APPLICATION FOR REMOVAL OR VARIATION OF A CONDITION FOLLOWING GRANT OF PLANNING PERMISSION (Ref: 20/02247/FULL). TOWN AND COUNTRY PLANNING ACT 1990. PLANNING (LISTED BUILDINGS AND CONSERVATION AREAS) ACT 1990.

REGENCY HOUSE, 1-4 WARWICK STREET, LONDON, W1B 5LT

On behalf of our client, Maslow's ("the Applicant"), we enclose herewith a Minor-Material amendment application to planning permission ref: 20/02247/FULL, which was approved on 18 December 2020. The approved description of development is:

Drawing Number
MS-DCM-06-DW-PL-41206
 Drawing Status
PLANNING

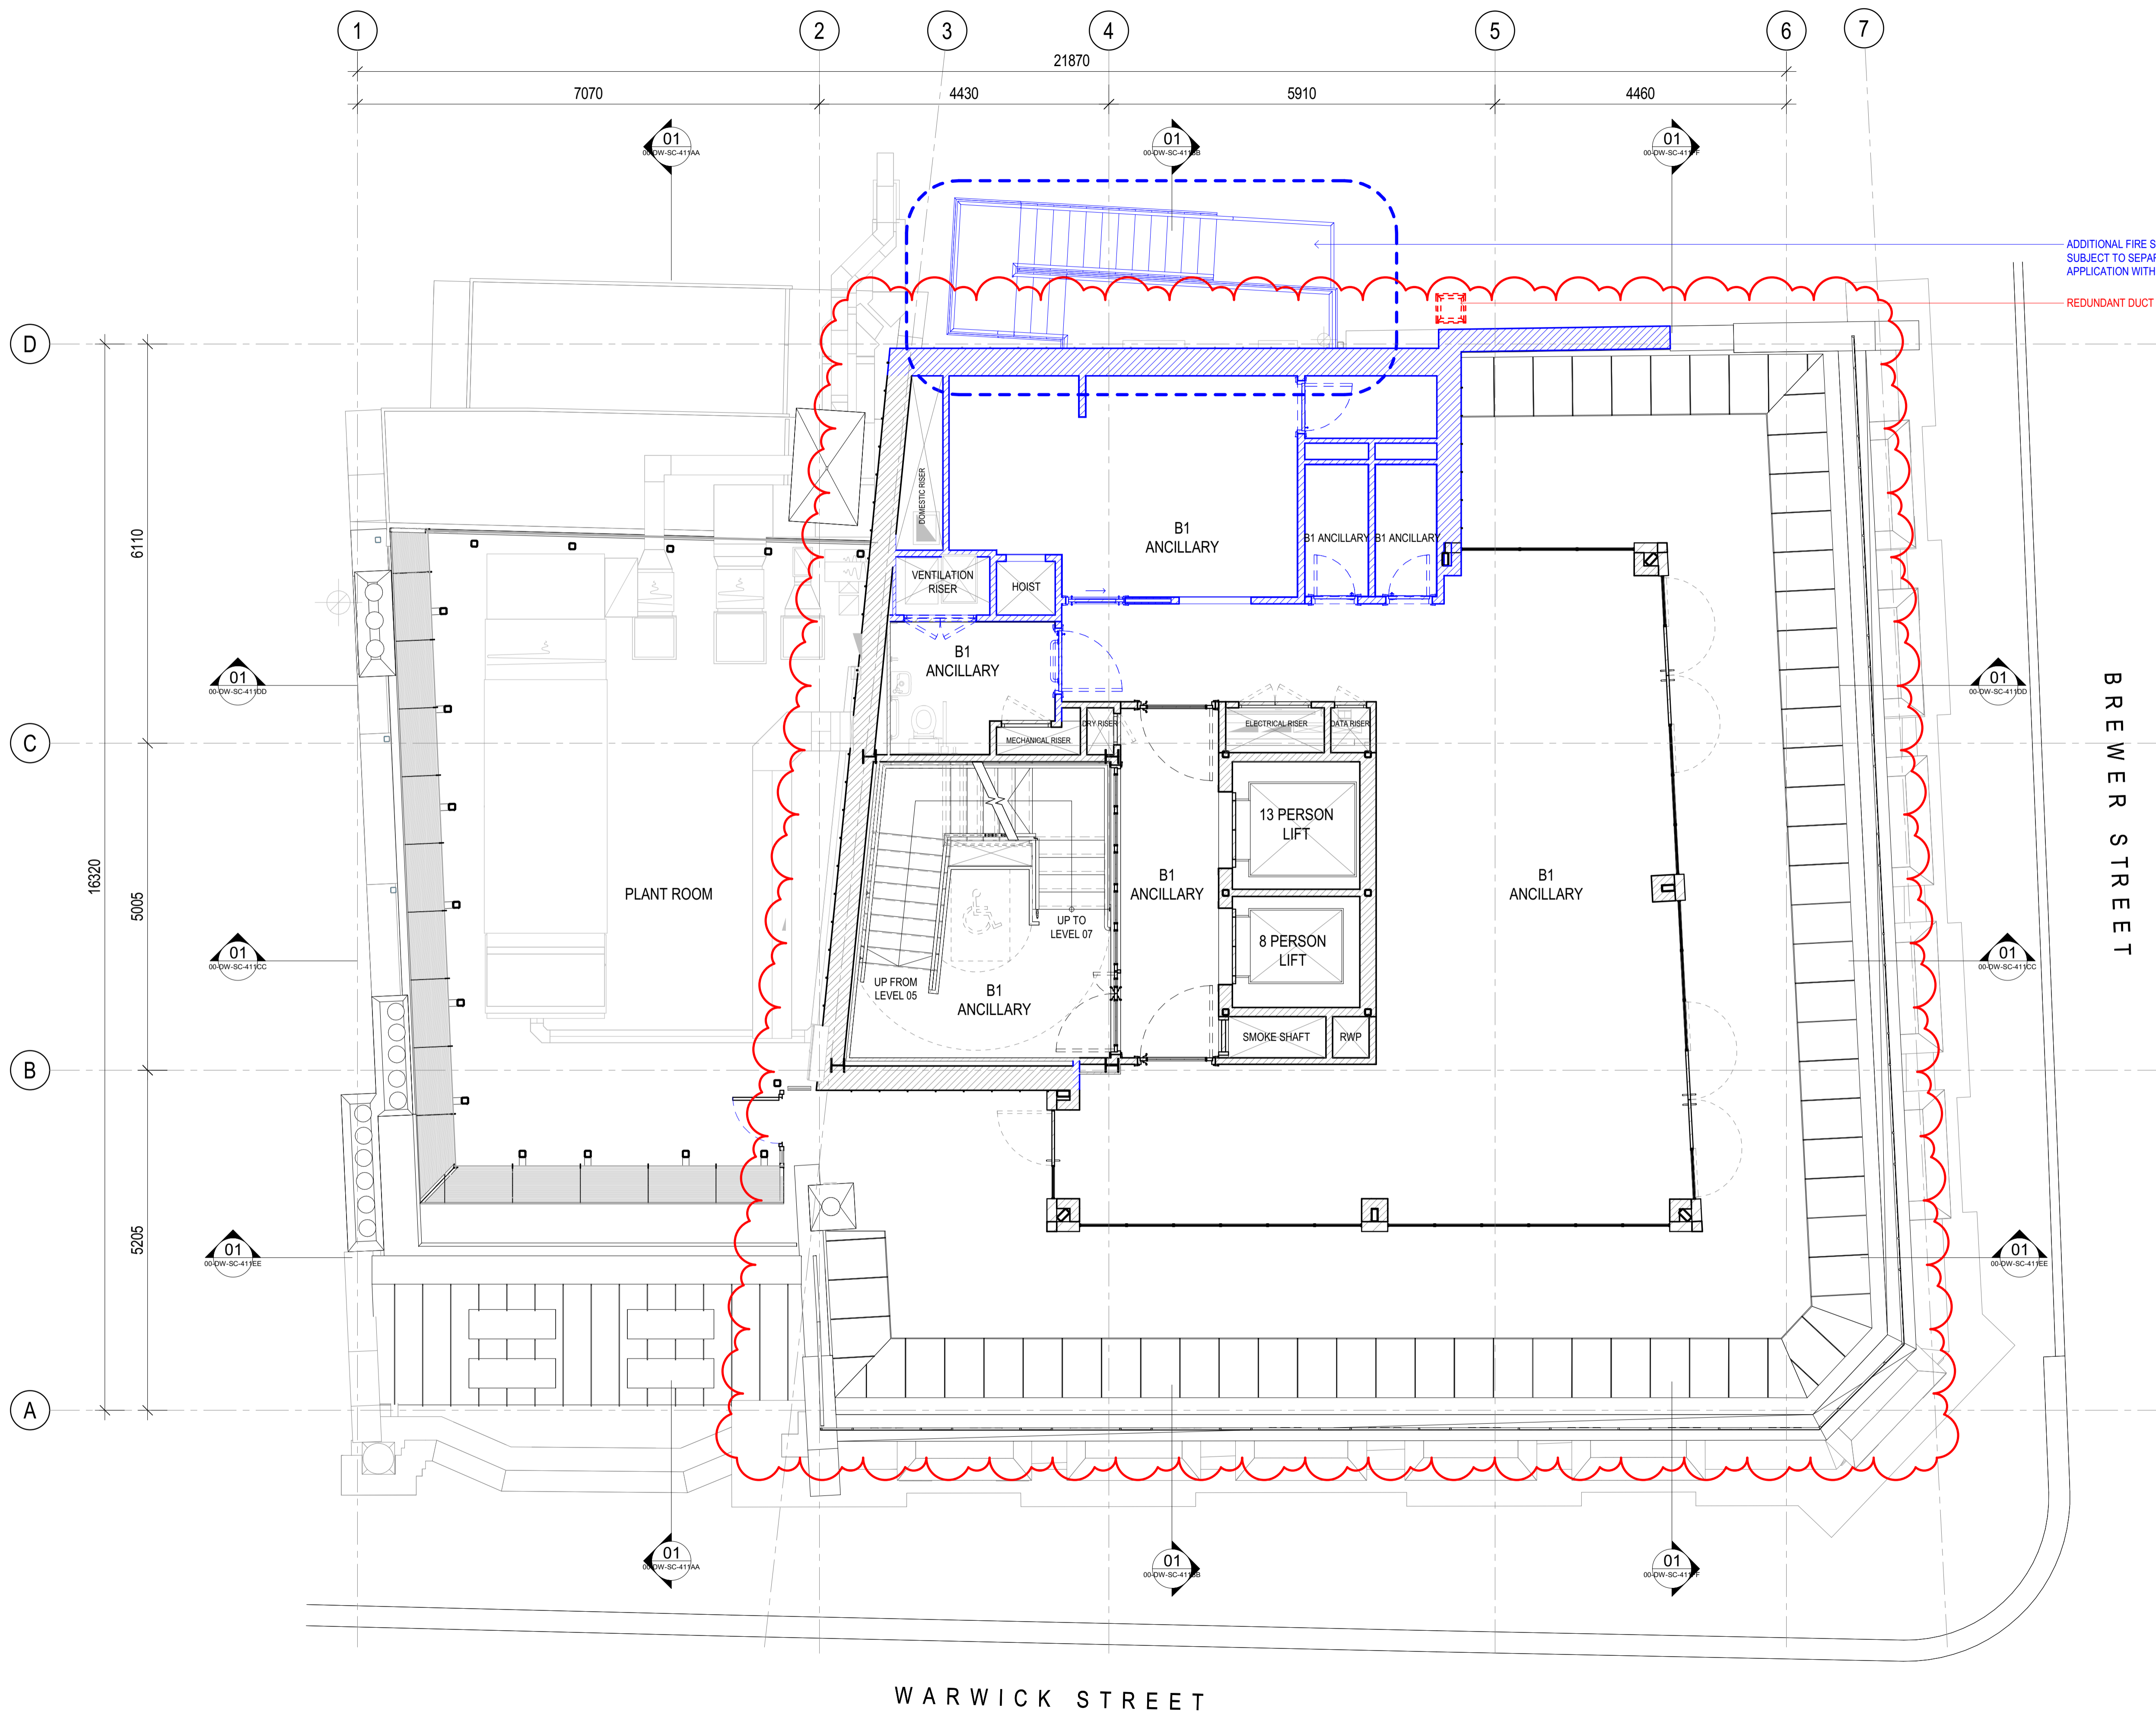
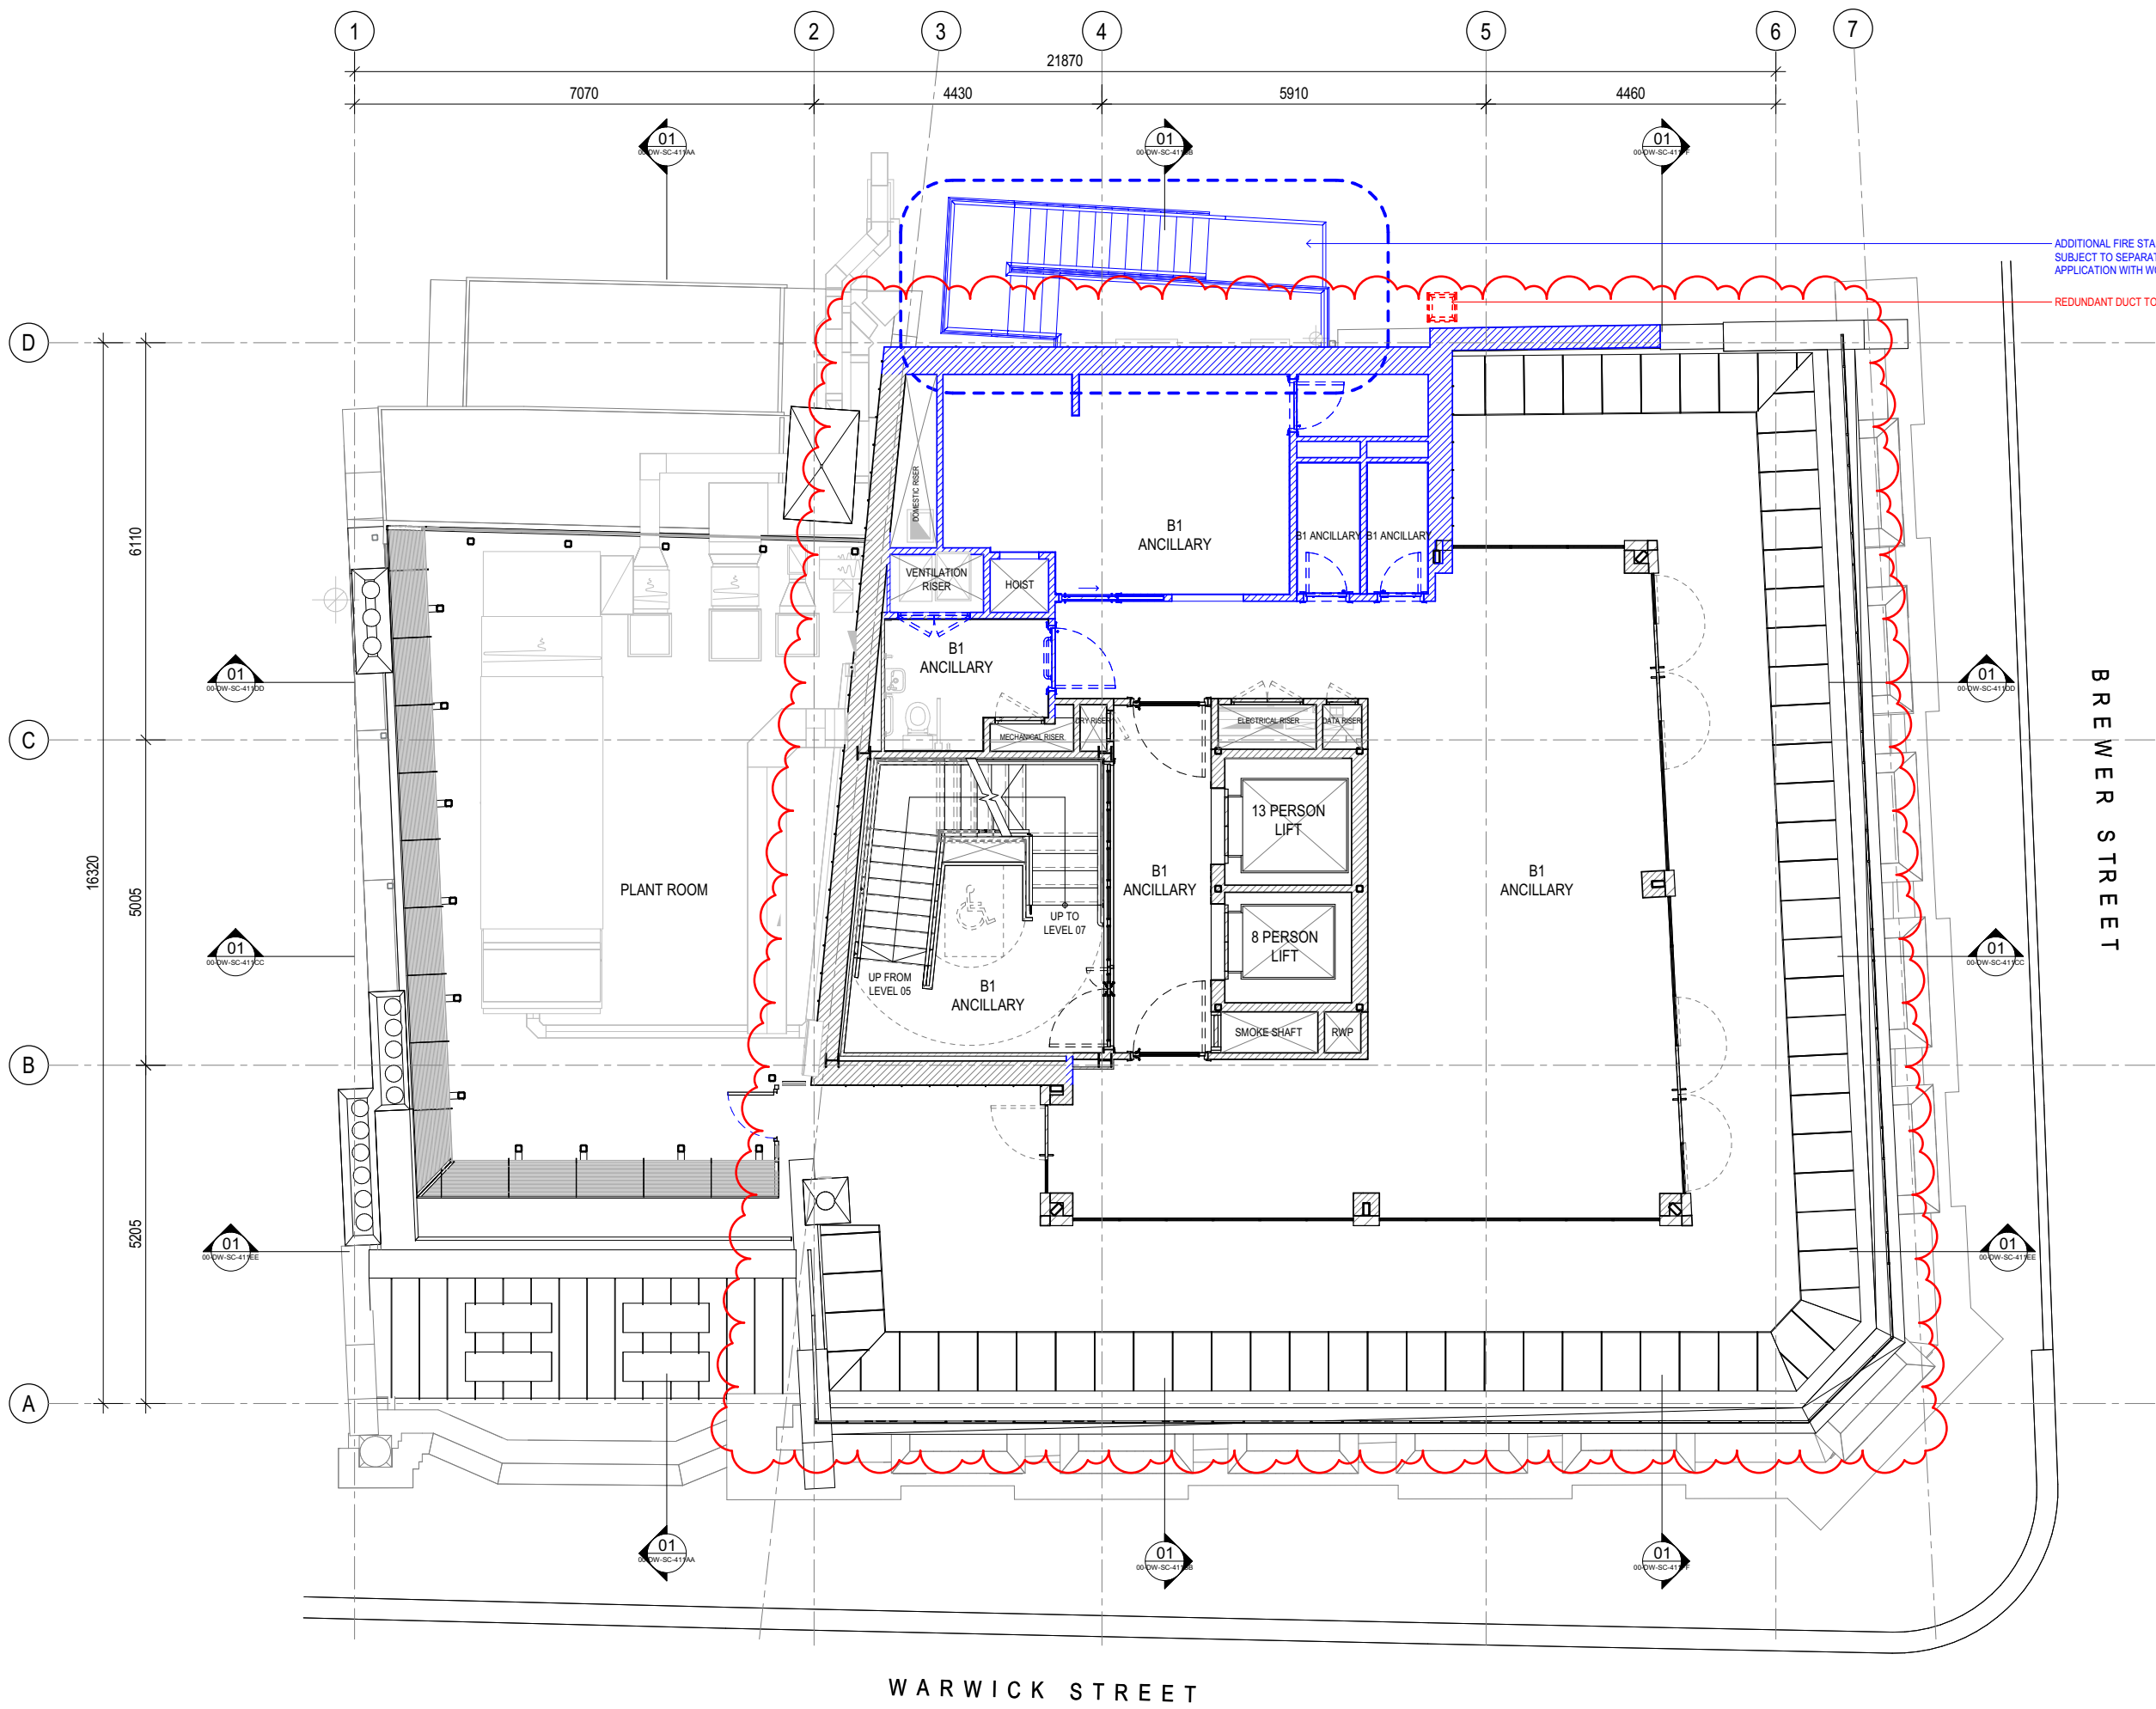
- Straightening of north-east façade to level 06. The consented layout is insufficient and restricts usable area on level 06. This is due to the consented scheme’s shallow roofline. We propose the straightening of the facade on the North-East façade to provide much needed useable footprint to the scheme. The approved area schedule remains the same.

- Removal of the roof overhang to the level 06 extension, providing a more open rooftop terrace.
- Introduction of a 45-degree balustrade to level 07 rooftop which follows the building line from level 06. Item is not visible from street level.
